Item No. **Report of the Head of Planning, Transportation and Regeneration**

Address 15 BROOKSIDE ROAD HAYES

Development: Erection of a first floor side extension, part first floor rear extension and conversion of flat roof to pitch roof on rear single storey extension

LBH Ref Nos: **30809/APP/2022/1634**

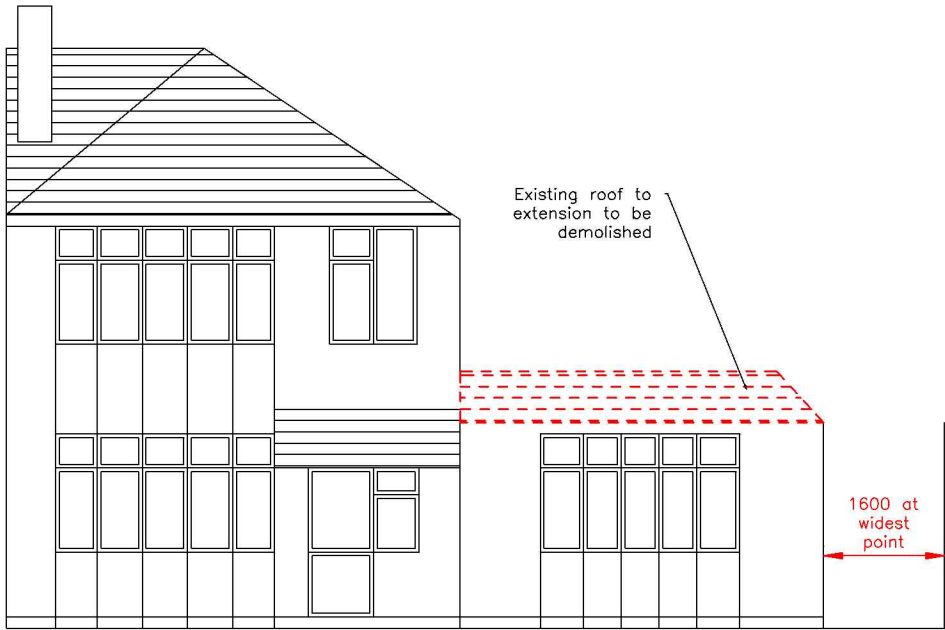
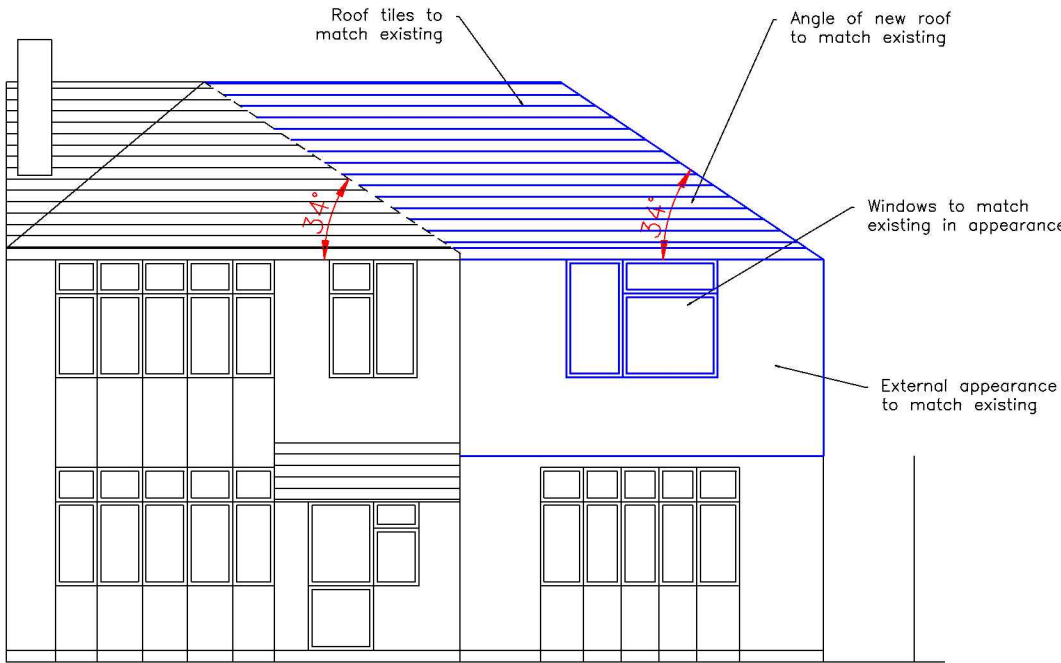
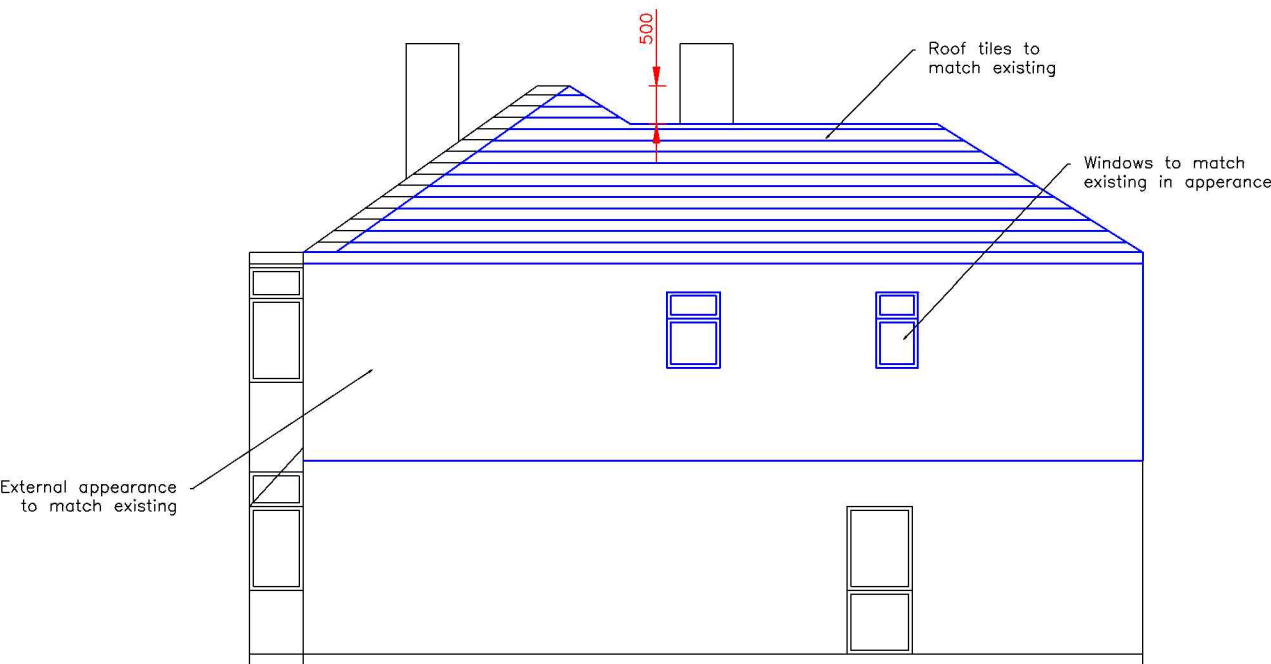
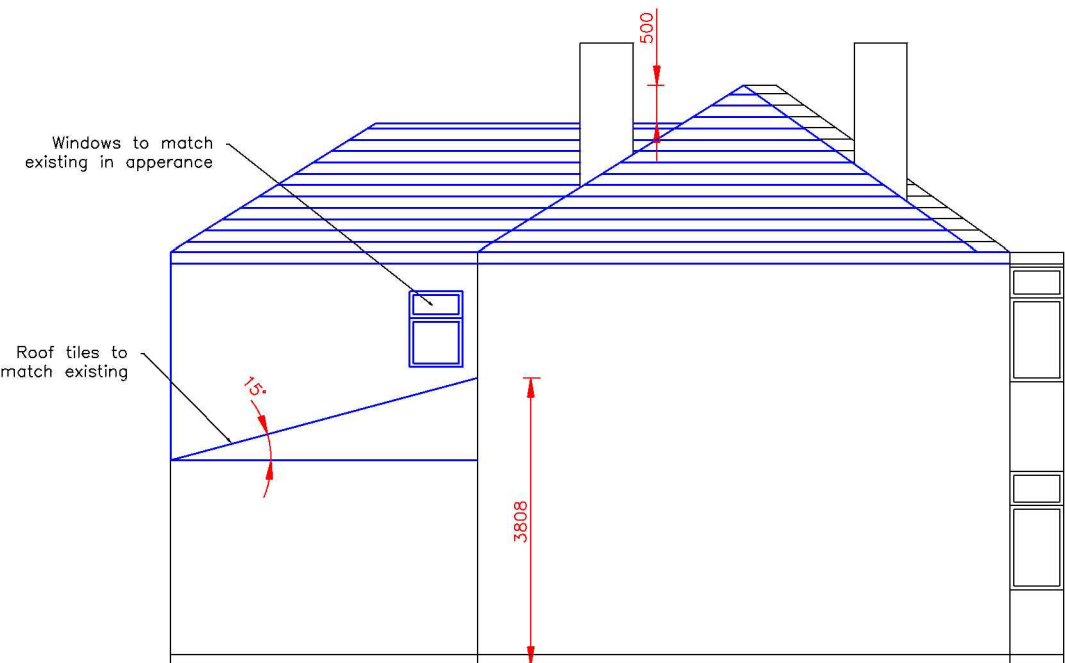
The application is located in an extremely prominent corner plot. Whilst it is acknowledged that the existing ground floor extension exceeds half the width of the original dwelling, the addition of a first floor would exacerbate and unbalance this end-terraced property. The proposed extension when viewed from both the front and side of the property would entirely engulf the original modest terraced property and detract from its architectural integrity. It is acknowledged that a gap of 1.6 m would be retained to the side boundary but this does not over-ride the harm that the significant increase in bulk in this prominent corner location would have on the visual amenities of the locality. The extension would also breach the return building line in Dorchester Way. The proposed development would therefore, by reason of size, scale, bulk and design, in this open prominent position, result in the total closing, at first floor level, of an important gap characteristic to the area, resulting in a cramped appearance. It is noted that the Inspector raised similar concerns in the previous appeal decision, which was for the same extension, stating:

The proposal therefore, by reason of its siting in this open prominent position, size, scale, bulk and design, would result in the loss of an important gap, at first floor level, characteristic to the area, resulting in a cramped appearance. The proposal would therefore represent an overdevelopment of the site to the detriment of the character and the visual amenities of the area and to this existing open area of the street scene. Therefore the proposal is contrary to Policy BE1 of the Hillingdon Local Plan: Part One - Strategic Policies (November 2012), Policies DMHB11, DMHB12 and DMHD1 of the Hillingdon Local Plan - Part Two (2020), Policies D4 and D8 of the London Plan (2021) and the NPPF.

Proposed First Floor Plan

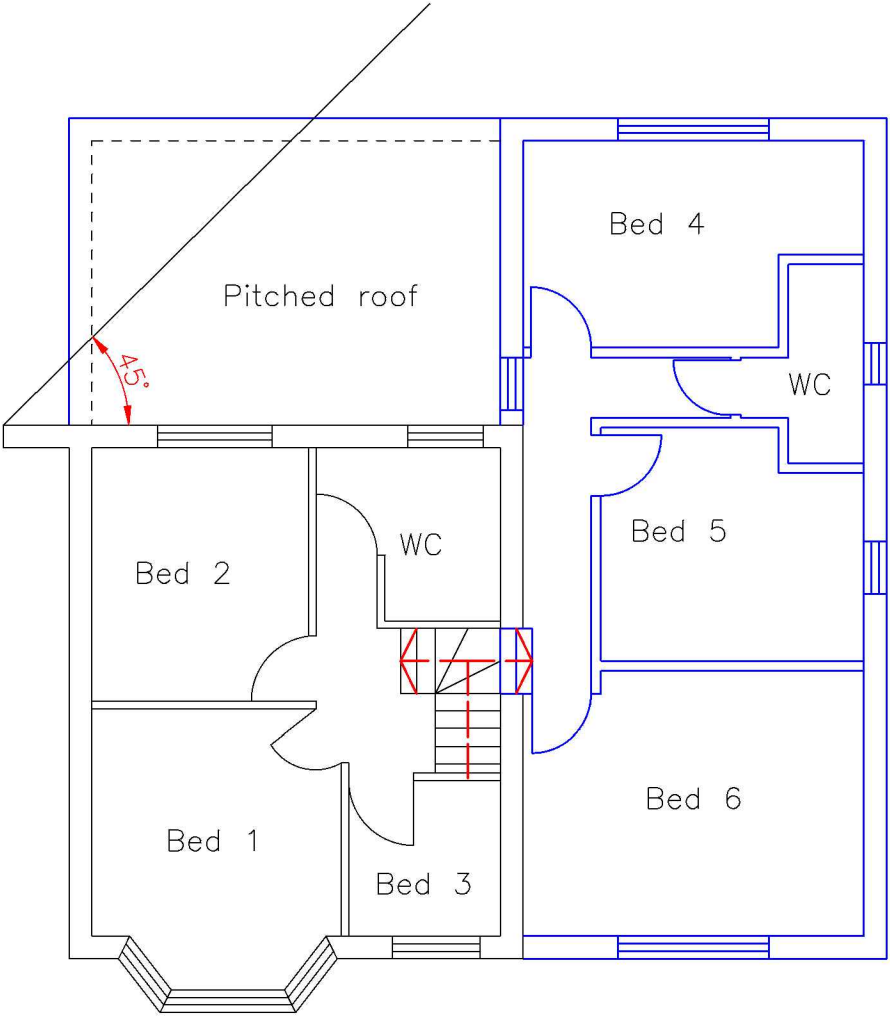
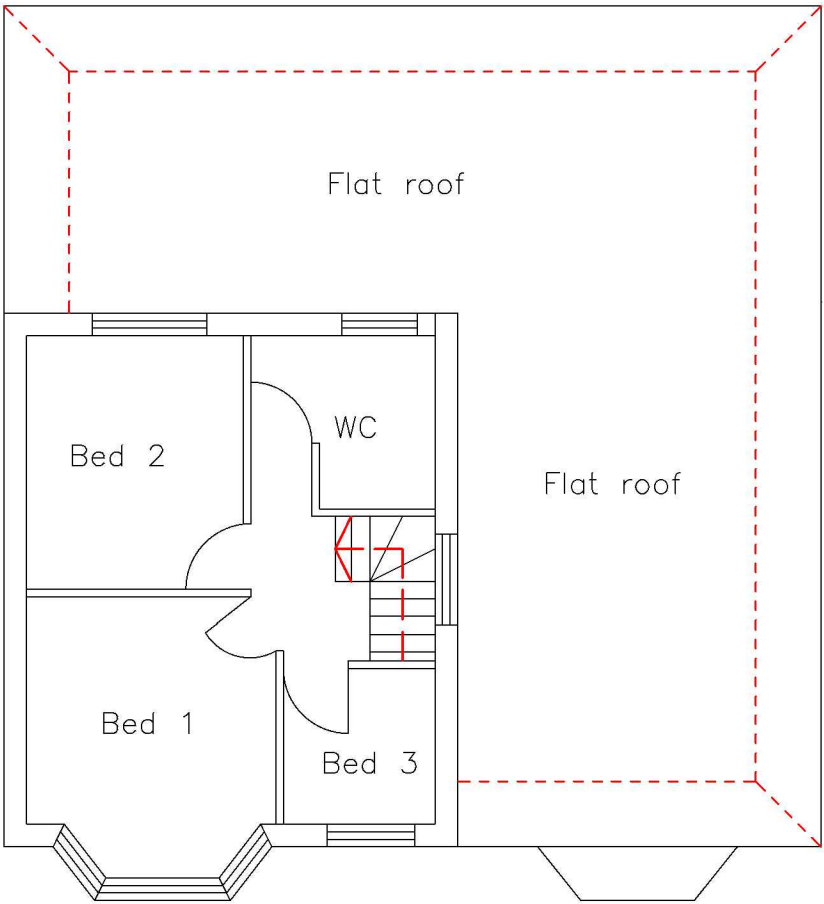
Given the degree of separation between the proposed first floor rear extension and the shared boundary with adjoining number 13 Brookside Road, the development would not result in an unacceptable loss of light or outlook. This is demonstrated by the 45 degree angle that has been plotted on the submitted plans. The increase in height over the existing single storey rear extension would further not have an impact upon the occupants of number 13 given that this property has a rear extension in line with that proposed. The submitted plans show a first floor side facing bedroom window towards number 13. It is considered that if the application were considered acceptable in all other respects, a condition could be imposed to secure obscure glazing. Therefore, it is considered that the proposed development would not constitute an un-neighbourly form of development.
